KIRKLEES METROPOLITAN COUNCIL INVESTMENT & REGENERATION SERVICE

DELEGATED DECISION TO DETERMINE PLANNING APPLICATIONS

Reference No:	2025/62/91306/W
Site Address:	60, Kaye Lane, Almondbury, Huddersfield, HD5 8XU
Description:	Erection of single storey extensions to front and rear and associated alterations
Recommending Officer:	Molly Storer

DECISION – CONDITIONAL FULL PERMISSION

Drawing	Scale @ A1
Proposed Plans and Elevations	1:100, 1:200
Drawing No.	Revision
3630 (0-) 08	-

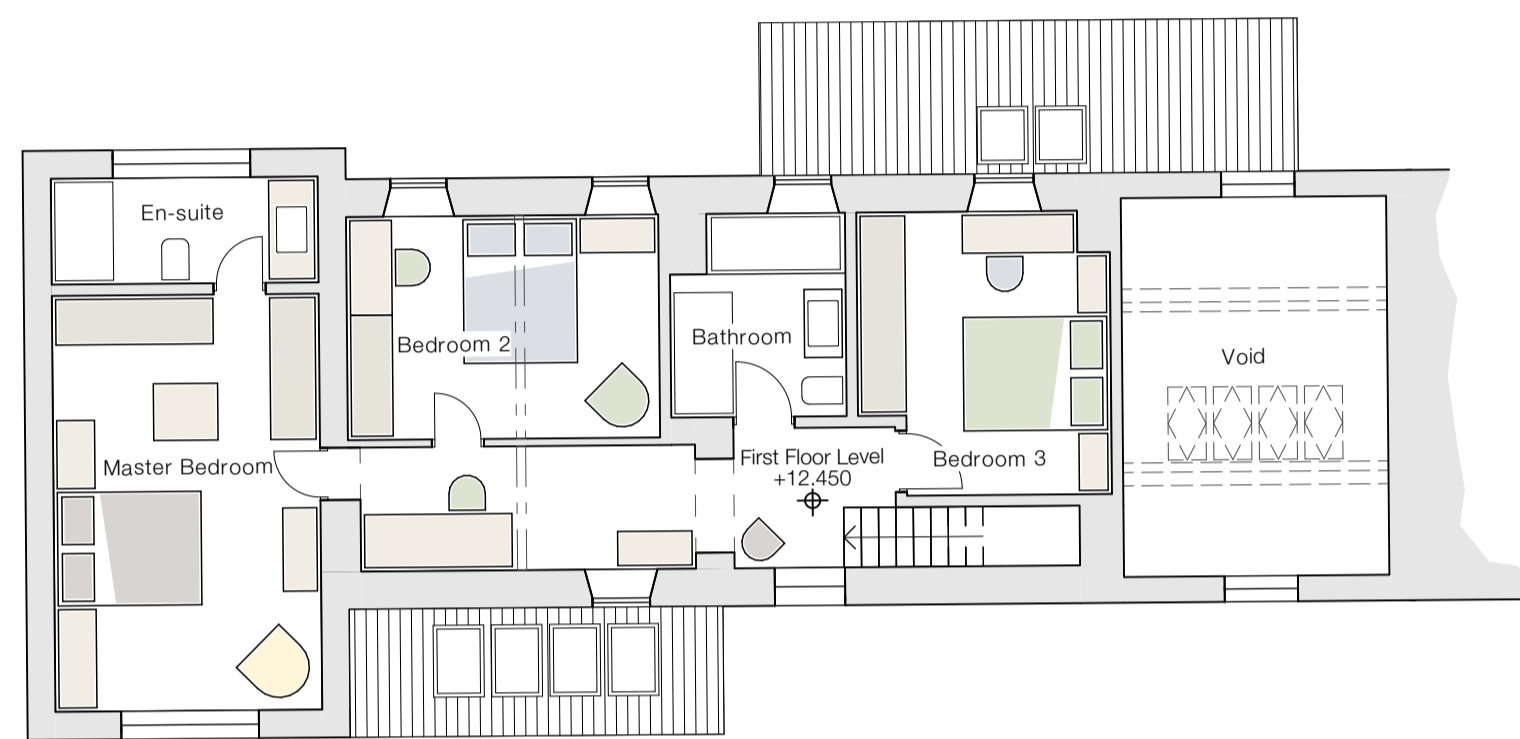
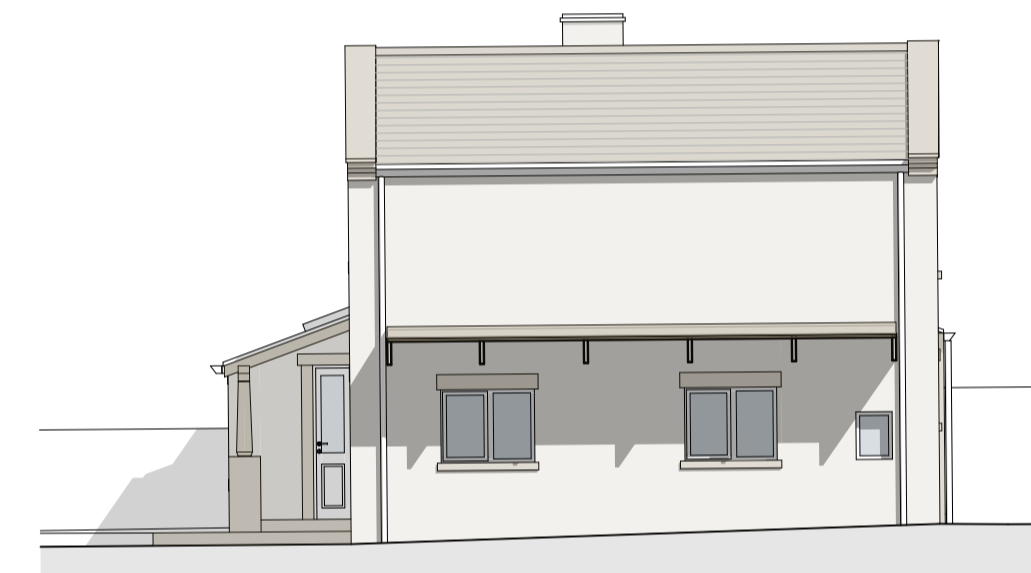
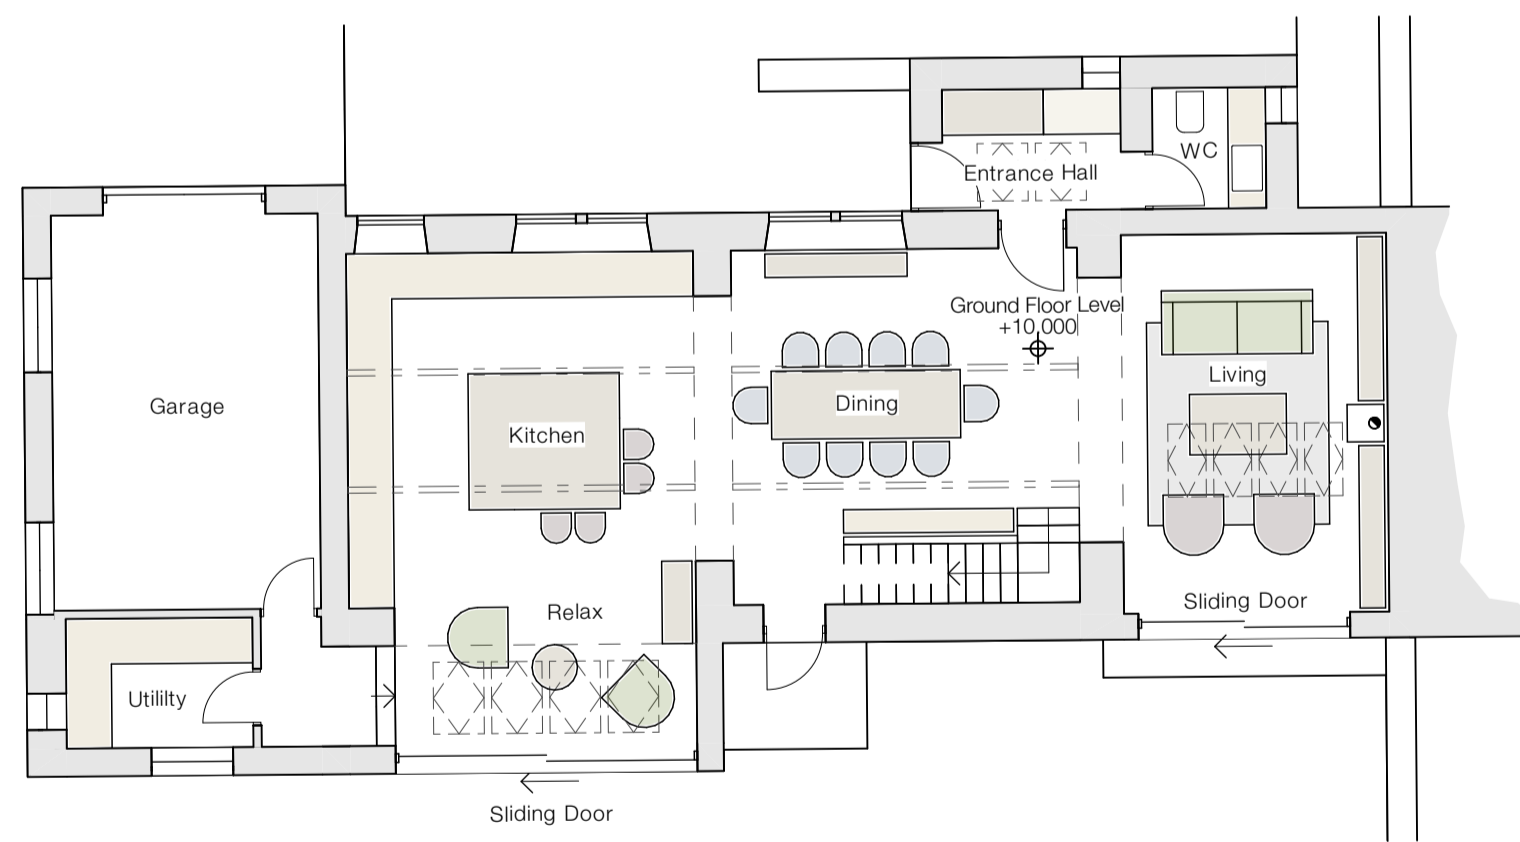
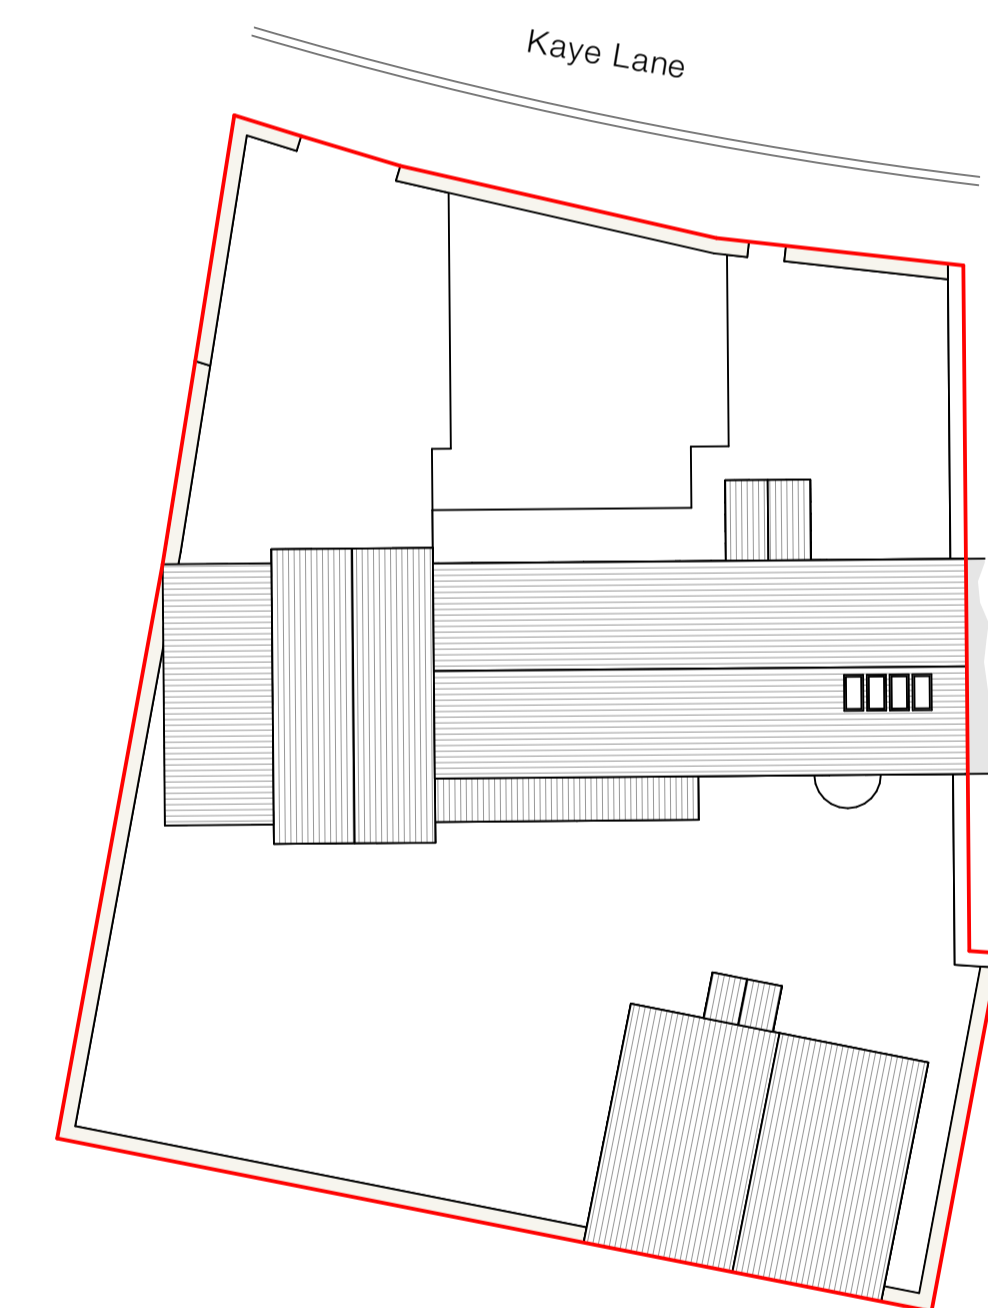
The agent was contacted following concerns raised by Conservation officers. It was considered that a section to the west of the building comes under the listed description for the adjacent property due to a break in the roof form of this section. It was considered that the front extension in the location shown on the original plans would appear incongruous to the character of the building. It was considered that the extended porch in close proximity to the listed building introduce an uncharacteristic feature harming its historic and architectural interest. The development would add bulking and mass to the front and as such would not appear in keeping with the historic architectural character, design and plan form of the host and be contrary to Key Design Principle 2 of the House Extensions and Alterations SPD and incompatible with Council's duties under the Planning (Listed Building and Conservation Areas) Act. Furthermore, they state that consideration should be given to reducing the scale of the glazed bi-folding doors on the elevation leading from the living room. Also reducing the 4 roof lights above these doors. This is because this element of the proposal is close in proximity to the Listed Building or Listed itself.

There is an existing rear extension at No.60 and whilst this would see its projection slightly increased, the width would be decreased maintaining a ~6m gap to the boundary with No.62. There would be no additional glazing in the elevation facing this property and the bifolding doors would look onto the applicants own land. The single storey front extension would not extend close

Given the single-storey nature of the proposed rear extensions and there 8m (rear extension) and 12m (front extension) setback from the eastern boundary, it is considered that the development would not result in any detrimental impacts in terms of overbearing or overshadowing. Additionally, the extensions are not expected to give rise to any significant loss of privacy beyond the existing situation, as the rear extension is screened by the extending rear projecting gable and there is only an entrance door to the side of the front extension.

Drawing	Scale @ A1
Proposed Plans and Elevations	1:100, 1:200
Drawing No.	Revision
3630 (0-) 08	B

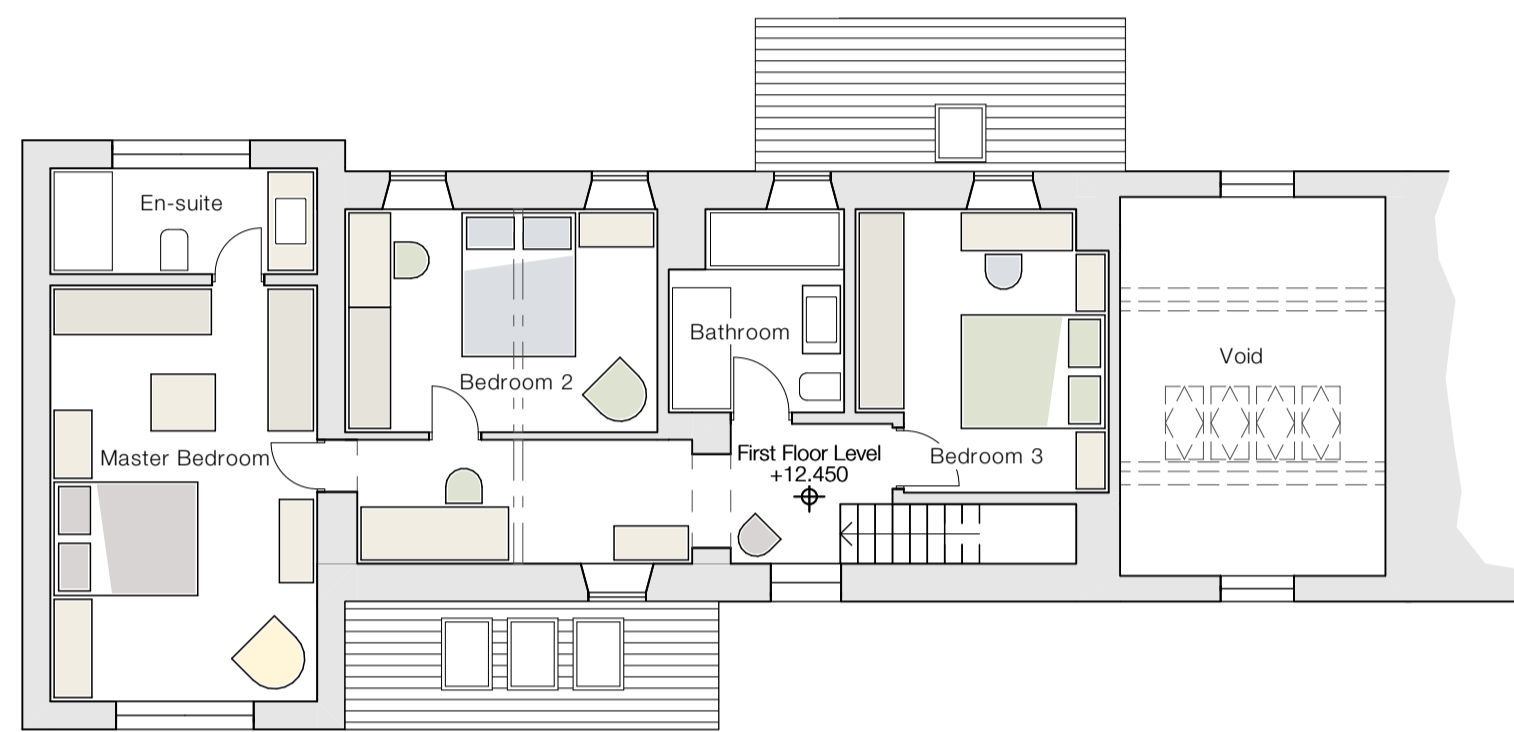
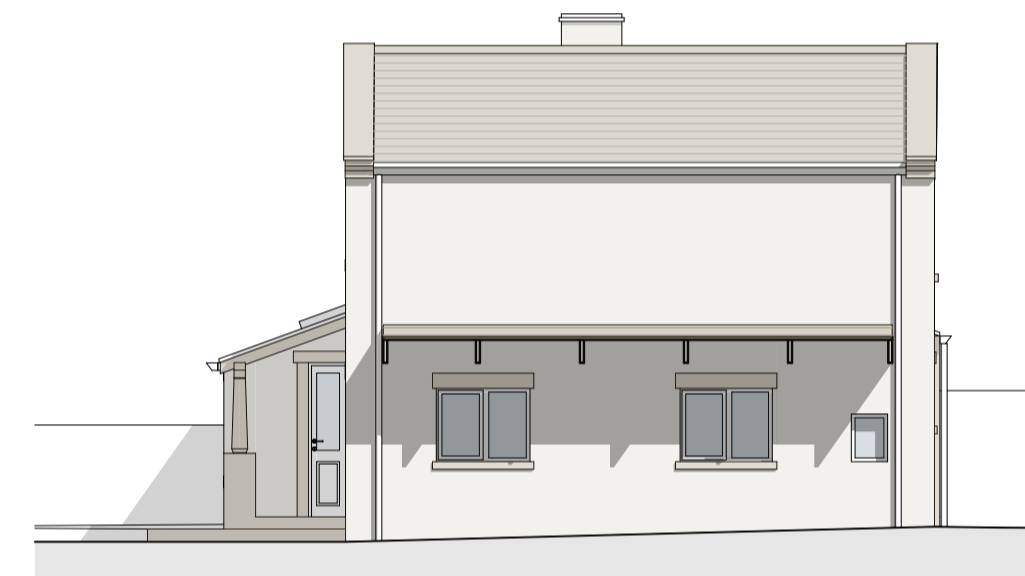
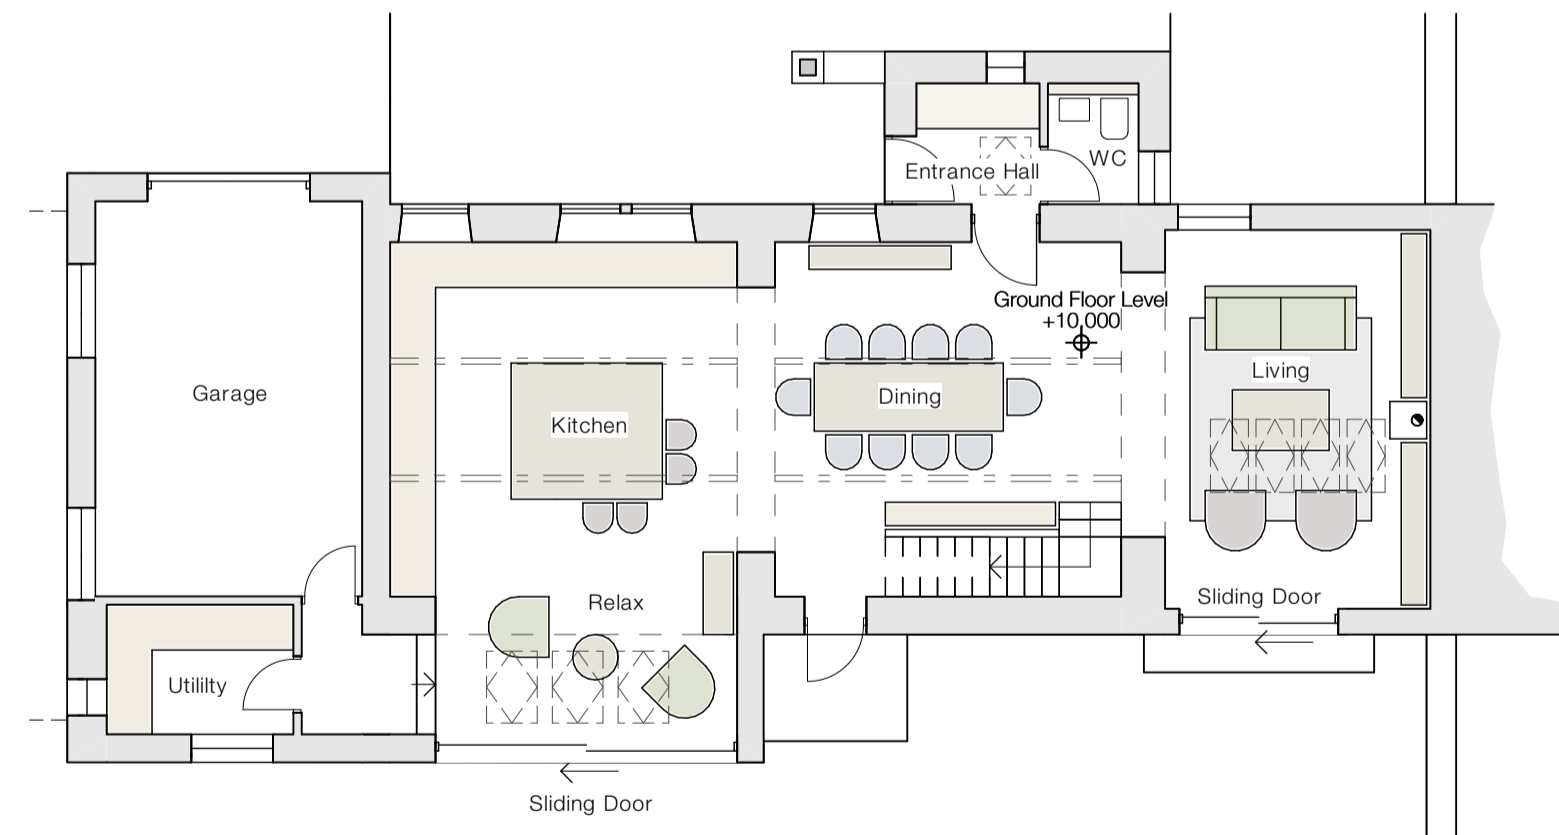
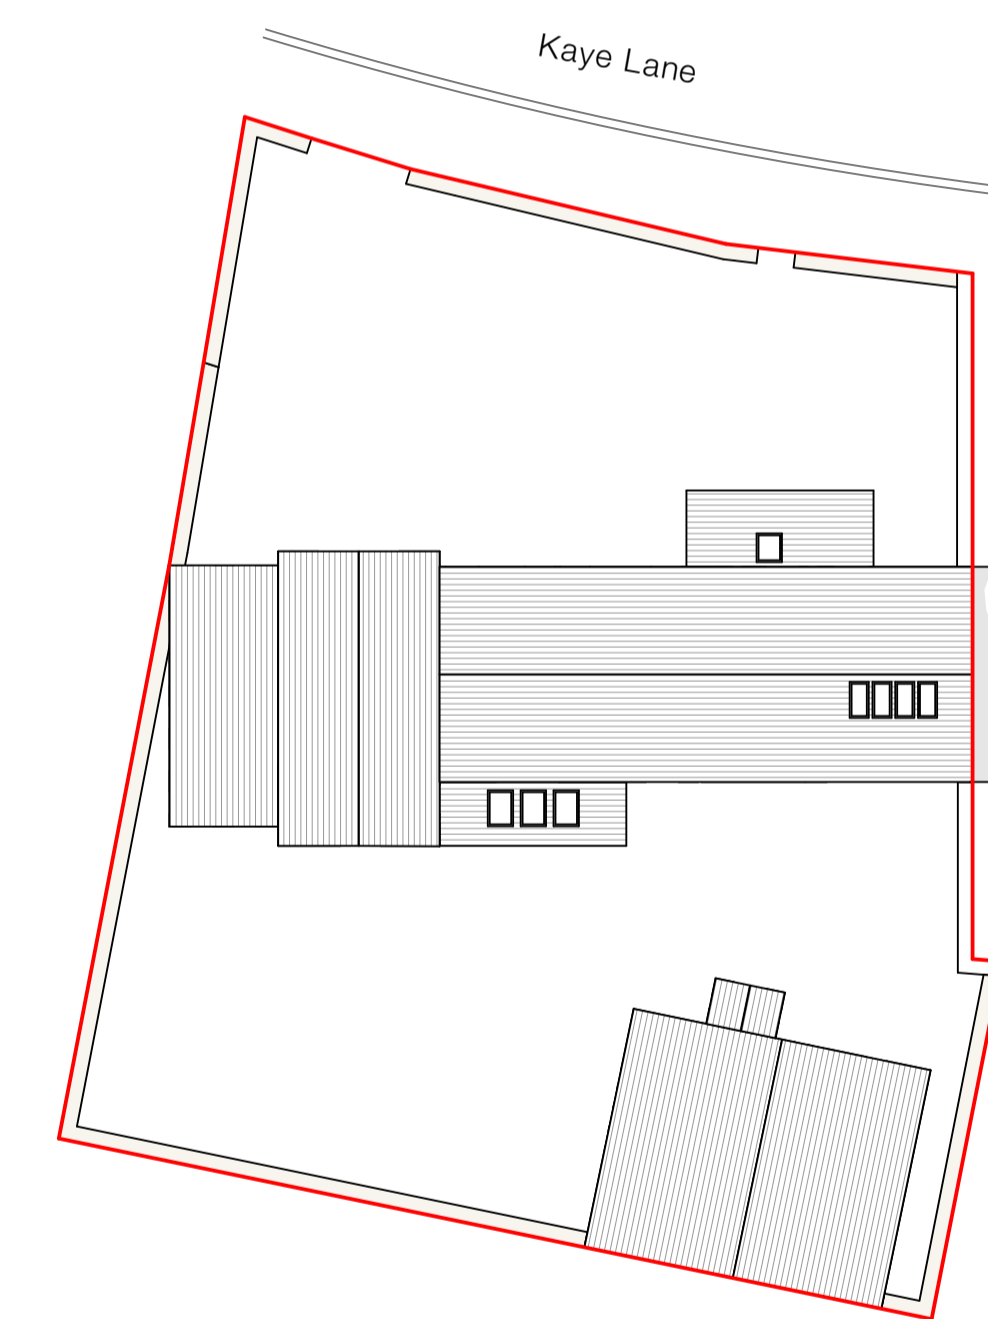
The agent sent amended plans showing the bifolding doors on the rear elevation out of the living room having a reduced width, a reduction of rooflights from 4 to 3 on the rear extension and the porch having a reduced width leaving the barn (step down in roof) element completely unaltered. These alterations were considered acceptable by Conservation officers.

Amended plans were submitted to amend the scheme such that it would be a design that protects the Listed Building following Conservation comments such as amended plans showing the bifolding doors on the rear elevation out of the living room having a reduced width, a reduction of rooflights from 4 to 3 on the rear extension and the porch having a reduced width leaving the barn (step down in roof) element completely unaltered. K.C. Conservation and Design were informally reconsulted and were satisfied that there would be minimal impact to the setting of the Listed Building .
